From
The Member-Secretary,
Madras Metropolitan
Development Authority,
No.8, Gandhi-Irwin Road,
Madras-600 008.

Letter No. B3/14694/96.

Sub: MMDA - Construction of BF+GF+3 of office
building @ door no 145, T.T.K. Road, Alwarpet in

X.S. no 3706/3, ~~Alwarpet Ms.~~ Block no 73 of ~~in~~ ^{ms} - Remittance of charges
Requested - Reg.

PLAN SHOWING THE PRO  
COMMERCIAL COMPLEX  
AT DOOR NO: 145  
T.T.K. ROAD ALWARPET  
MADRAS 13 FOR THE  
GOVT SERVANTS AND  
PUBLIC SERVICES CO-OPERATIVE  
HOUSING SOCIETY LTD

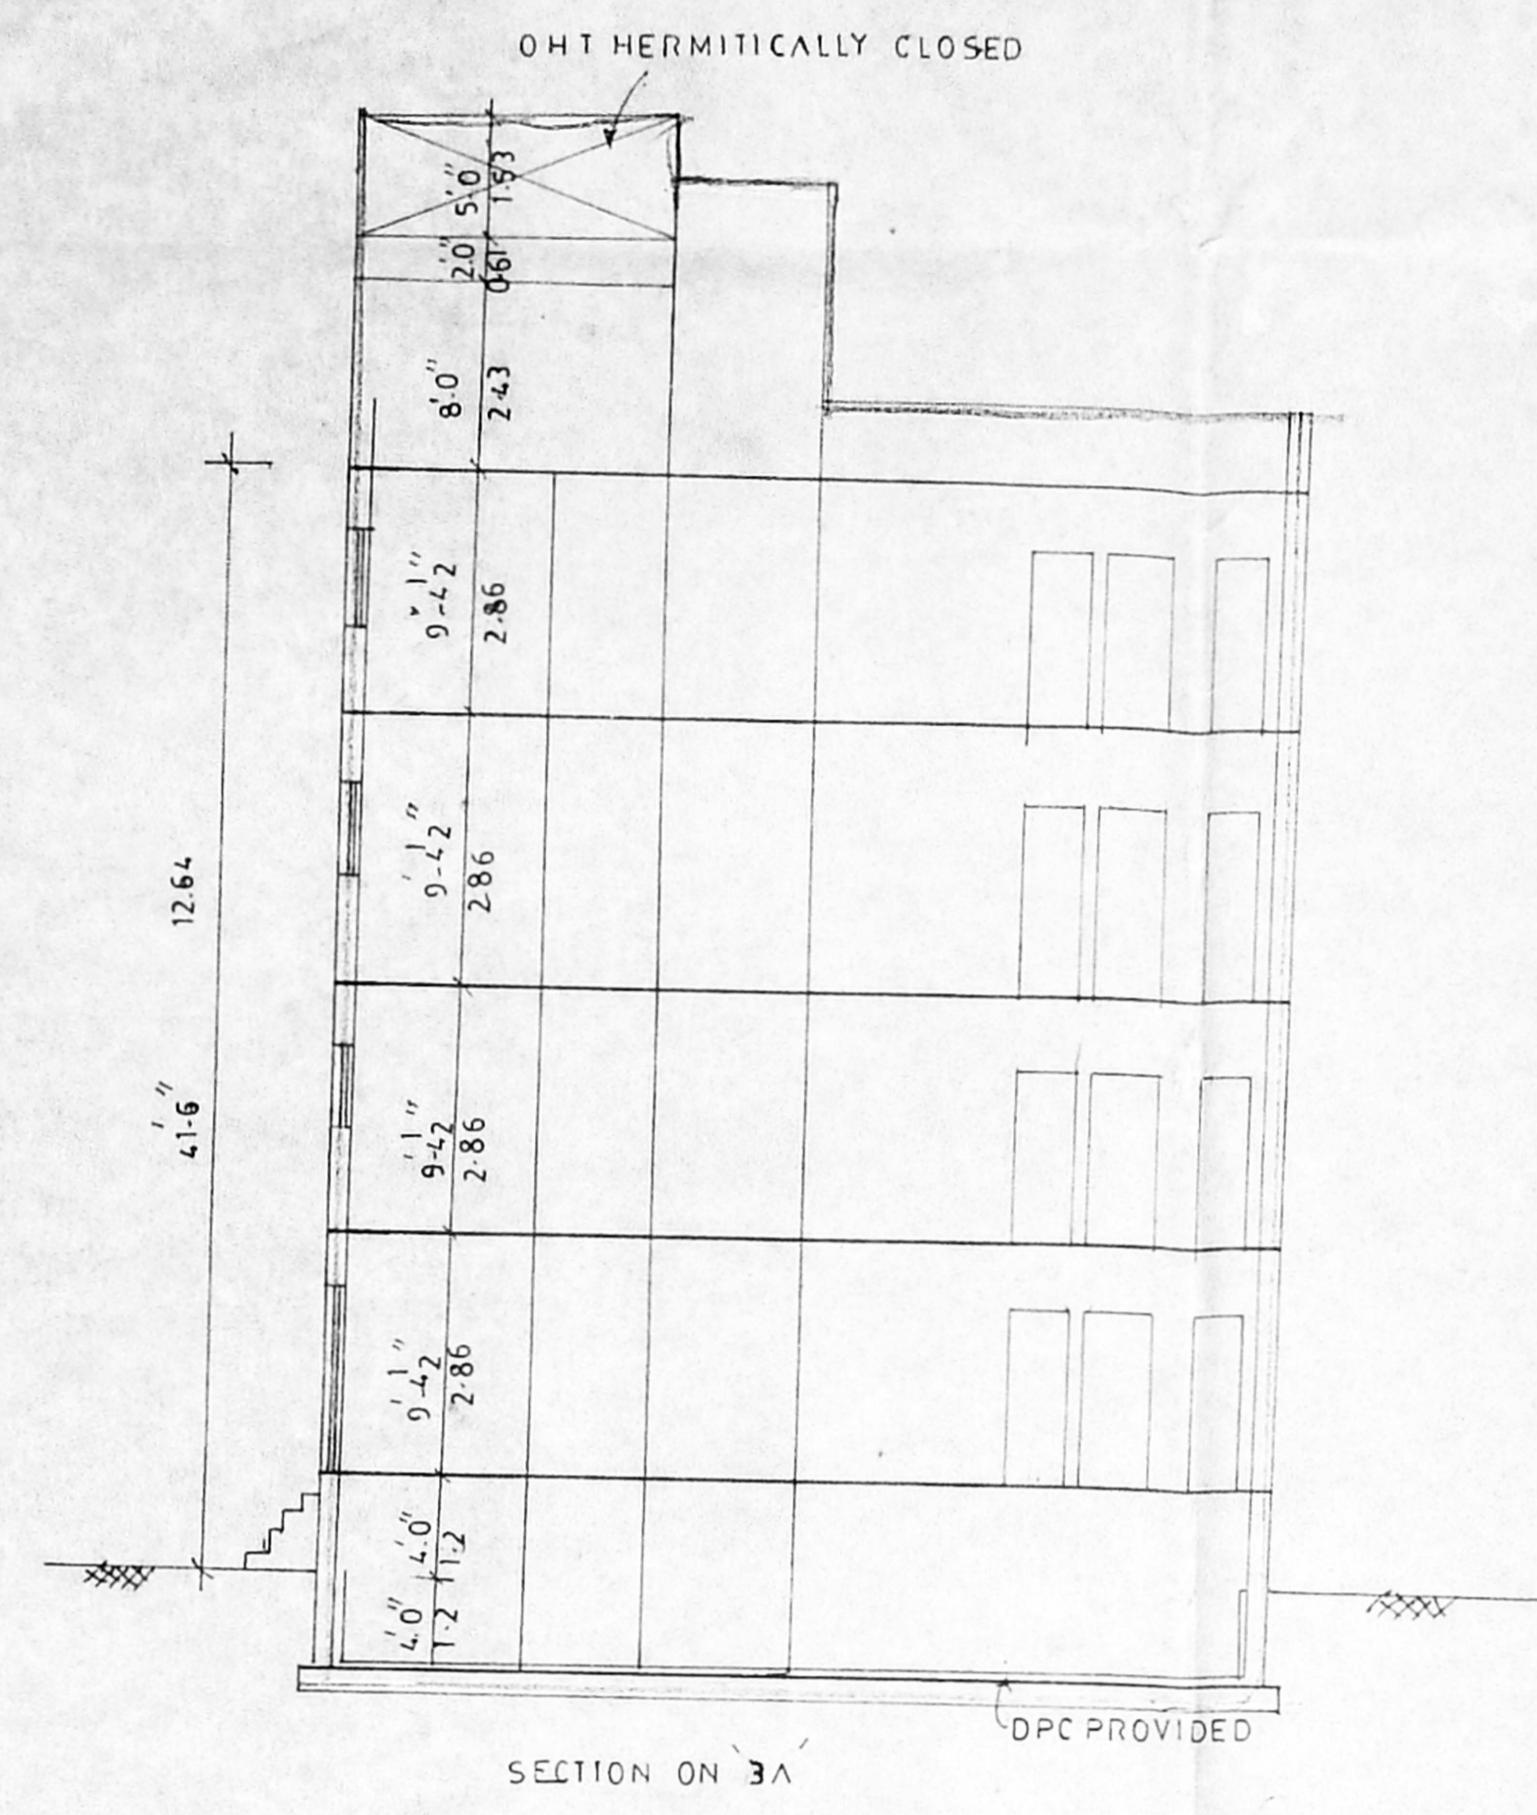
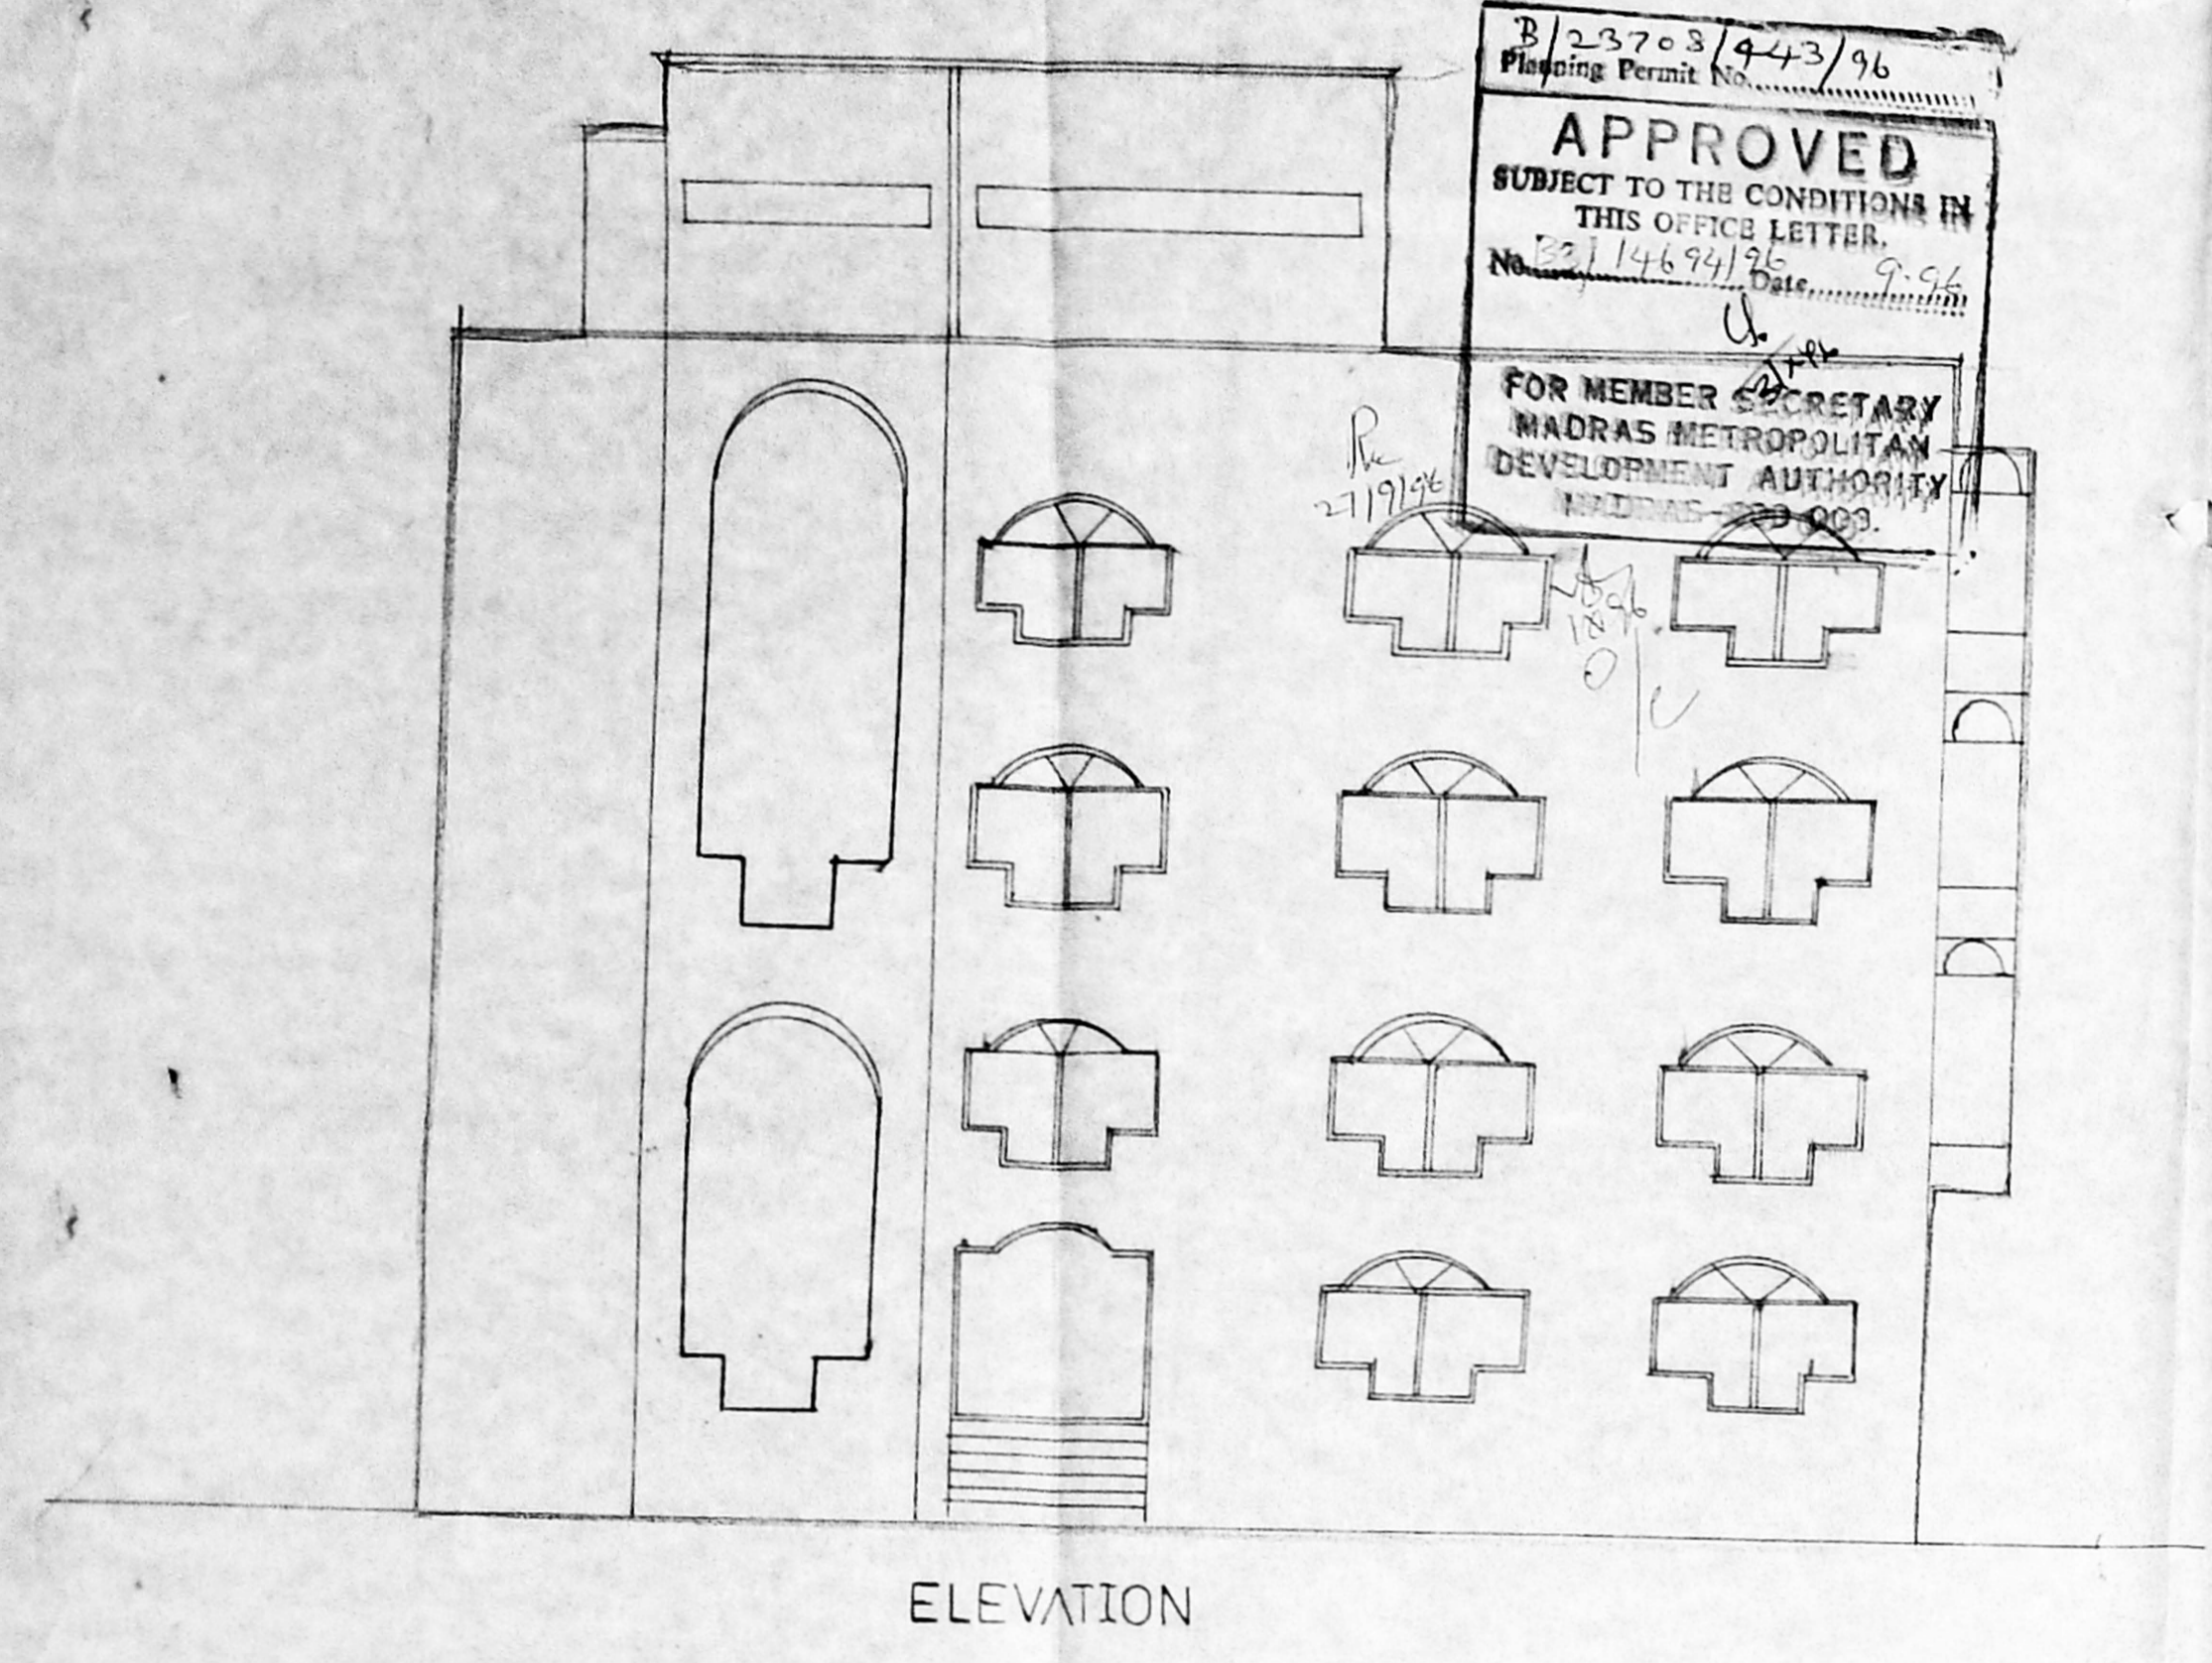
(c) You are requested to furnish the ~~following~~ ^{4 copies of} R.P showing

- i) ~~Setback on west not shown~~ [But more than the Regd 3-16m]
- ii) ~~Site plan to be drawn with specific indication of Splay~~
* left now [i.e. site Boundary to be marked excluding the space left for Splay.]
